**RE: SUBMISSION TO SSD-45121248 NERINGAH SENIORS HOUSING & HOSPITAL**

**Address: 4-12 Neringah Avenue South, Wahroonga**

### Ku-ring-gai Council's submission to SSD-45121248 Neringah Seniors Housing & Hospital at 4-12 Neringah Avenue South, Wahroonga

DRAWING TITLE
Landscape Plan - Stage 2 Ground

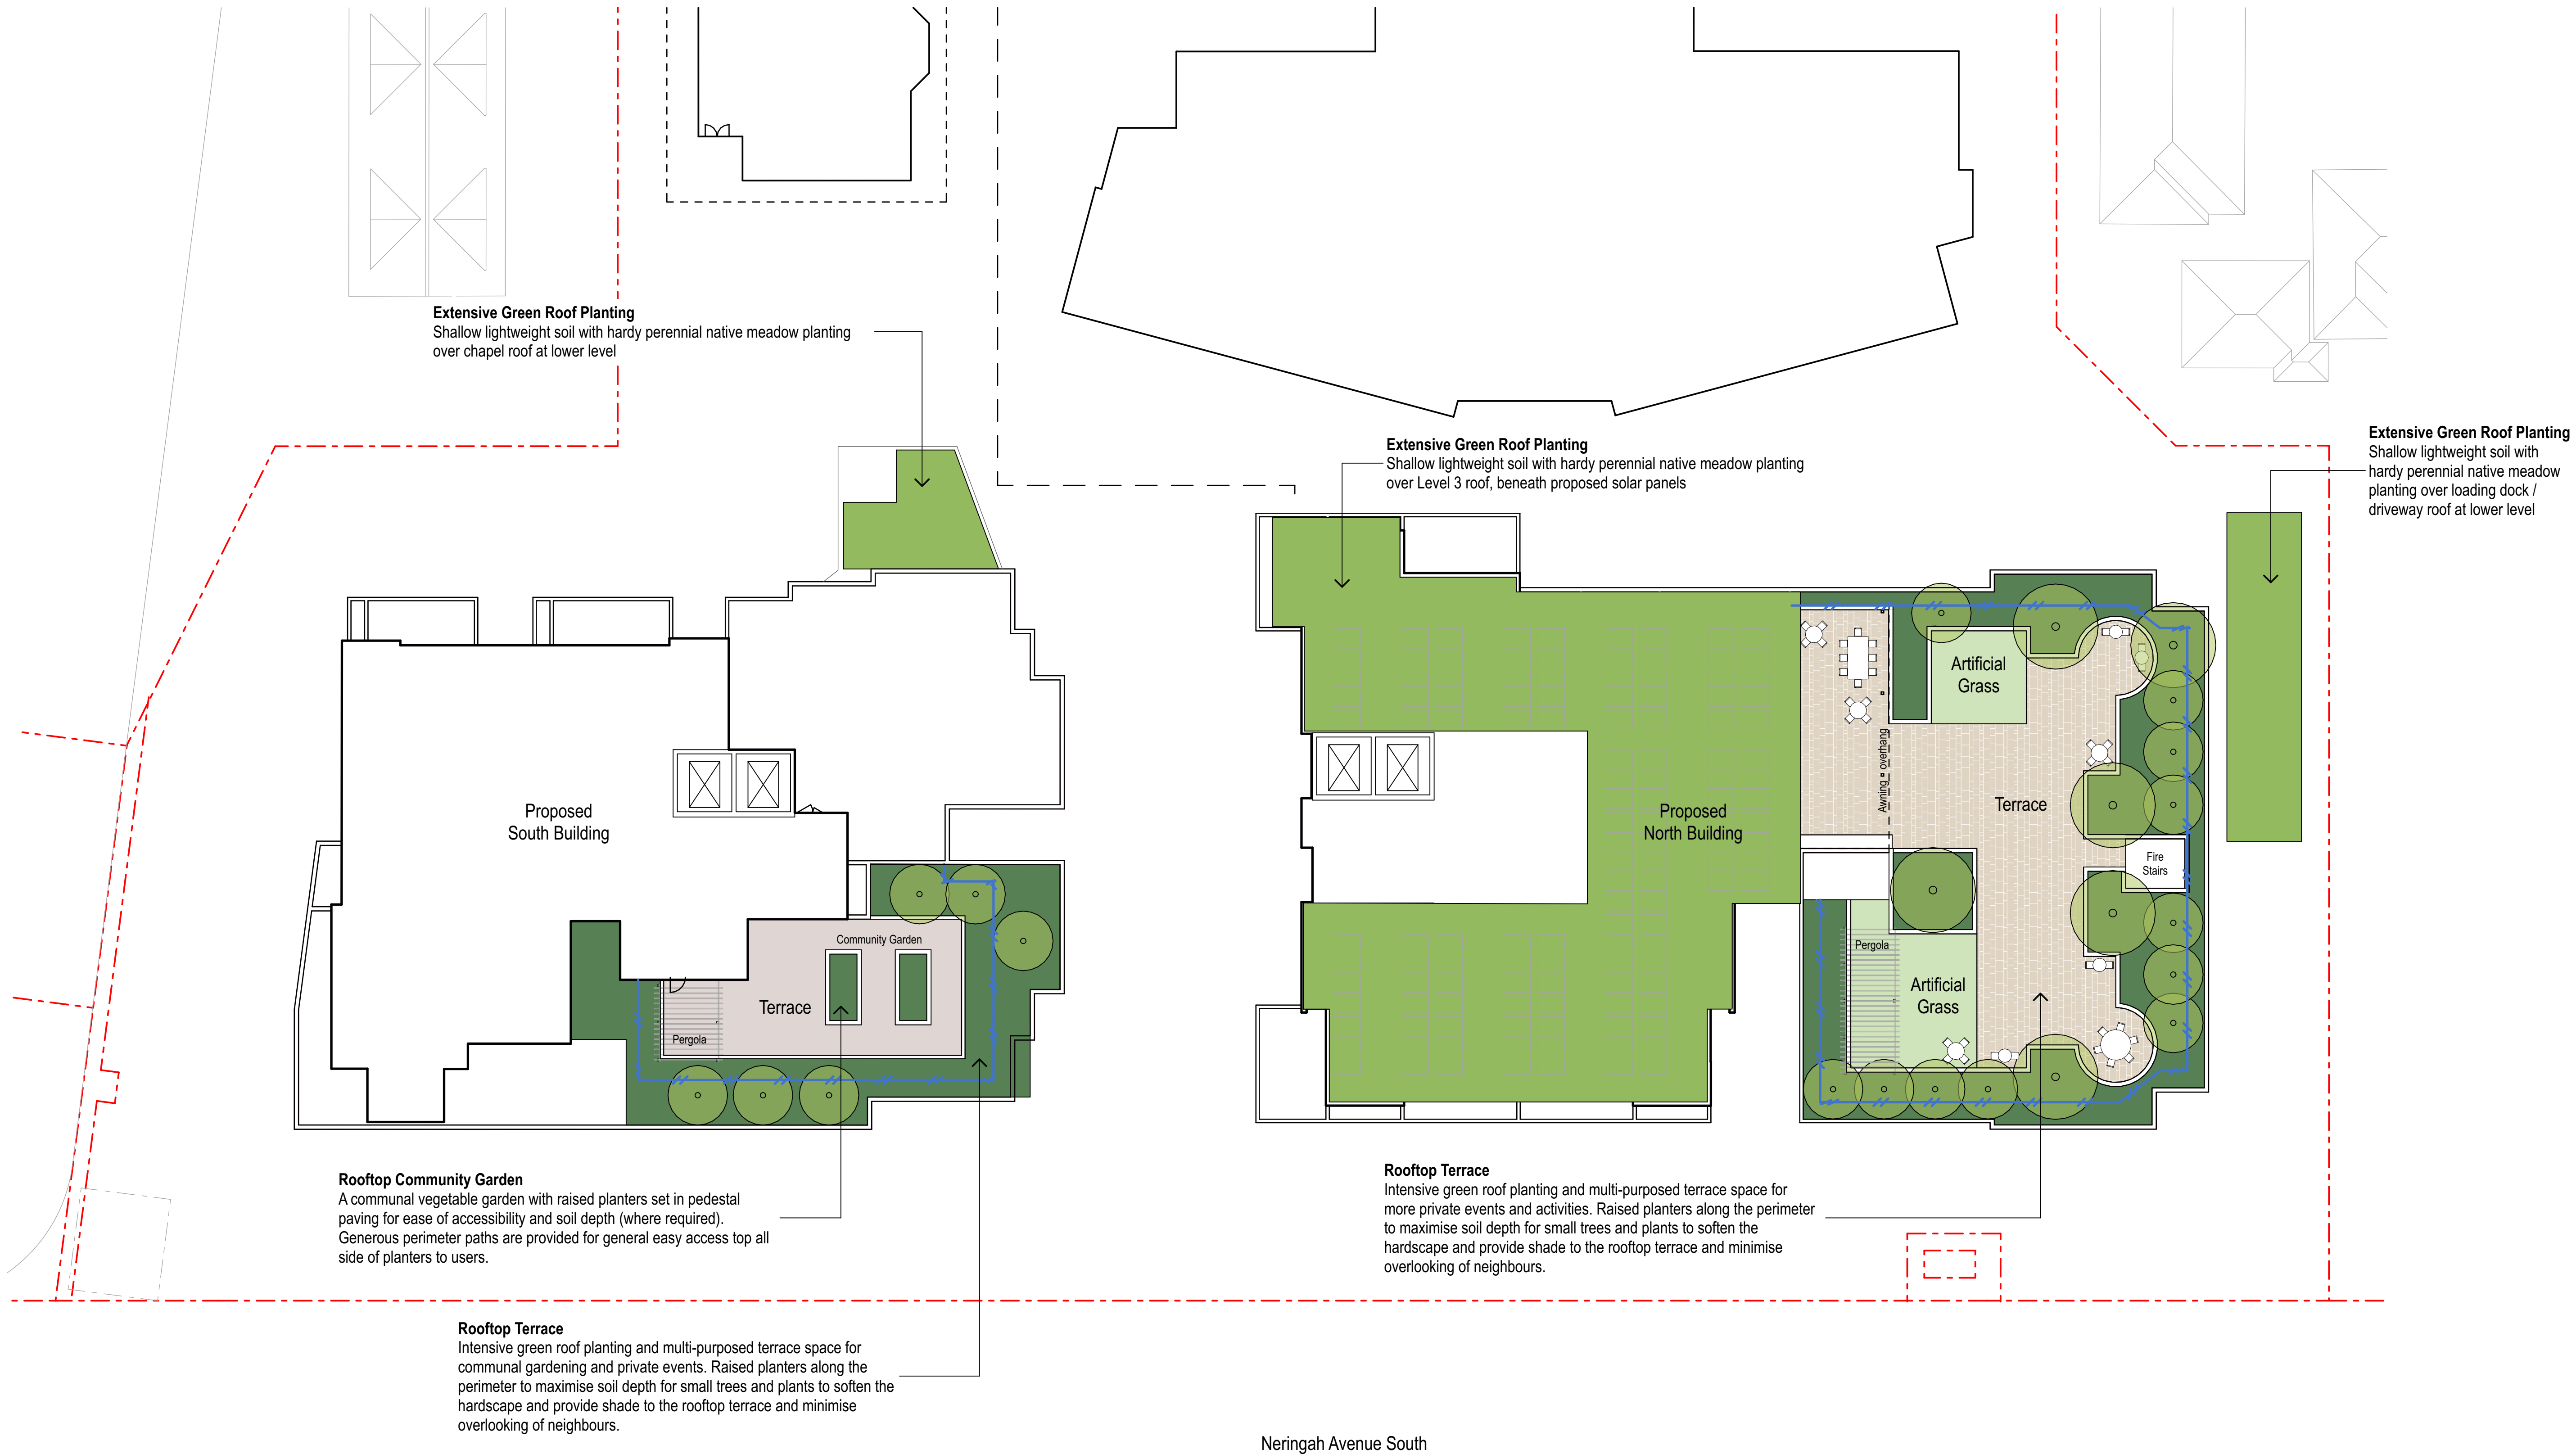
Areas of deep soil capable of sustaining new large canopy trees typical of the landscape character of the area within front setback are compromised due to basement setback from Neringah Avenue South, on-site detention (OSD) and proximity elsewhere of structures, such as walls and OSD tank within the setback reducing available soil volumes and deep soil landscape widths.

Deep soil is absent to the northern driveway adjacent the residential flat building.

The encroachment of the basement into the front setback compromises the provision of deep soil within this setback and the provision of substantial plantings of medium and large canopy trees typical of the current and desired landscape character of the area. Deep soil should be maximised within the frontage.
